Rezoning Transportation Analysis

Petition Number: 2022-139

Date	Description
1-25-23	First Review (TM)
2-22-23	Second Review (TM)
03-30-23	Third Review (TM)

RZ-1

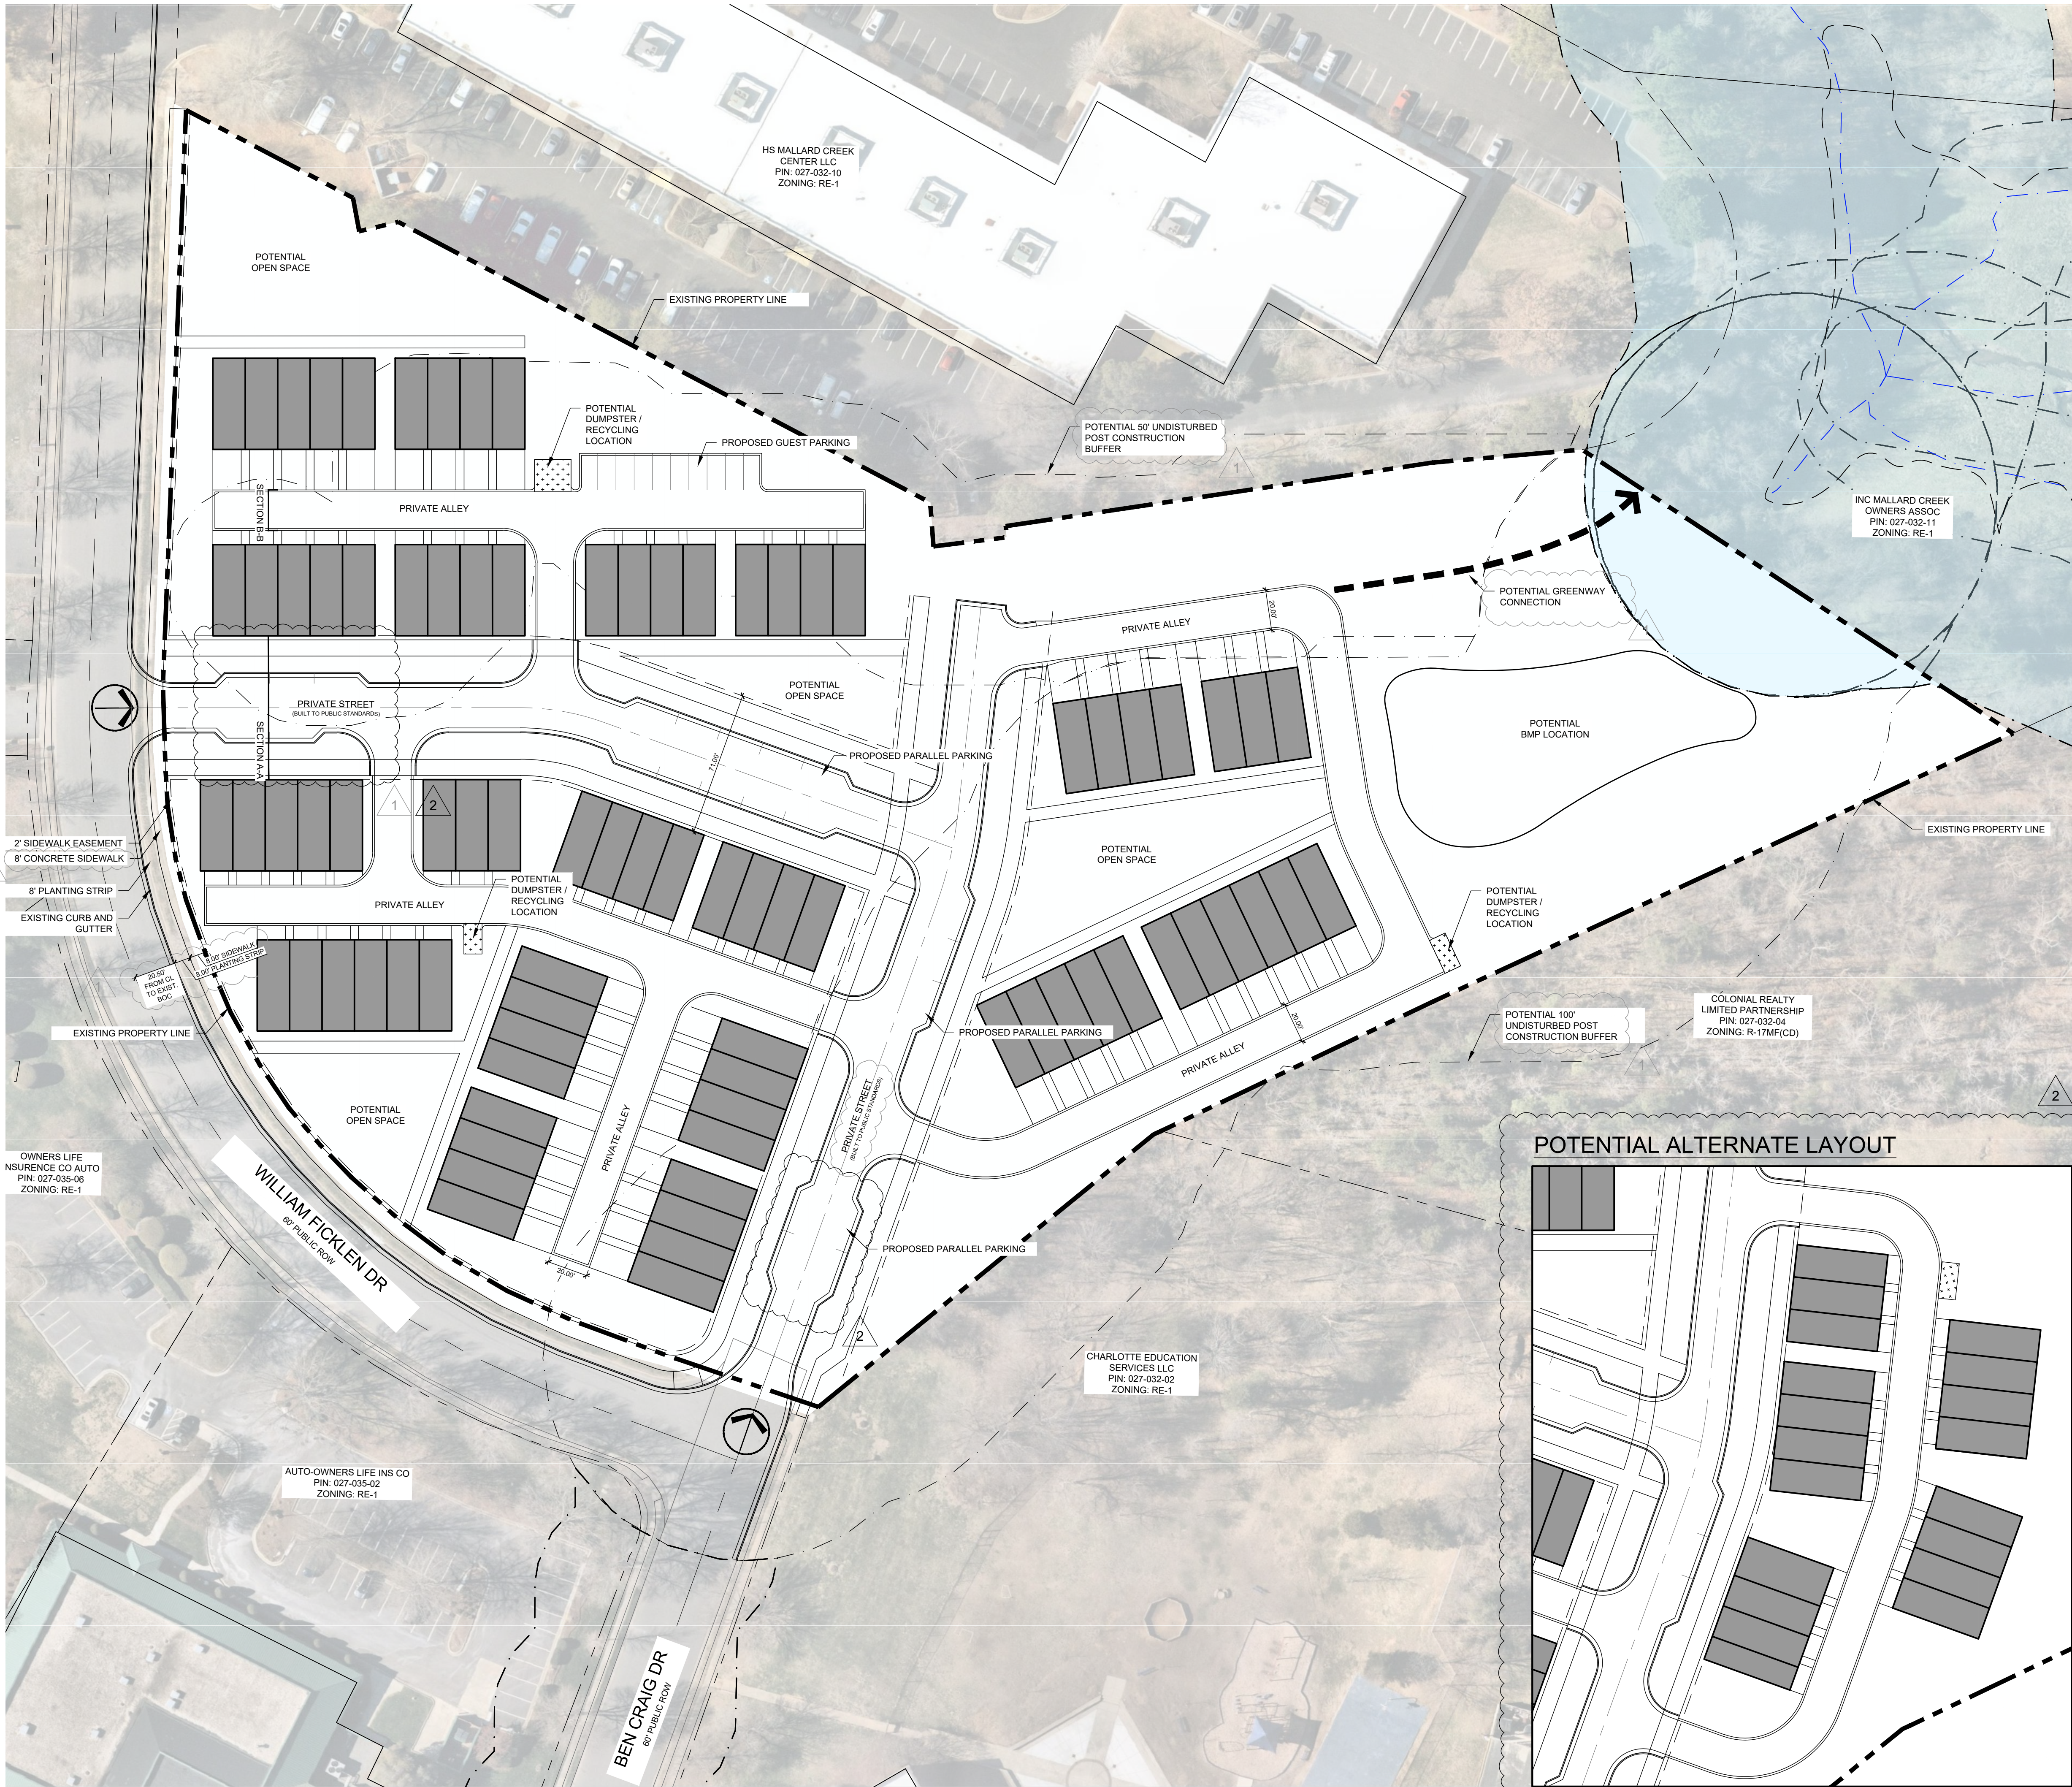
4. **Outstanding Comment from 01-25-23:** Add a conditional note specifying "A Right-of-Way Encroachment Agreement is required for the installation of any non-standard item(s) (irrigation systems, decorative concrete pavement, brick pavers, etc.) within a proposed/existing City-maintained street right-of-way by a private individual, group, business, or homeowner's/business association. An encroachment agreement must be approved by CDOT prior to construction/installation. Contact CDOT for additional information concerning cost, submittal, and liability insurance coverage requirements."
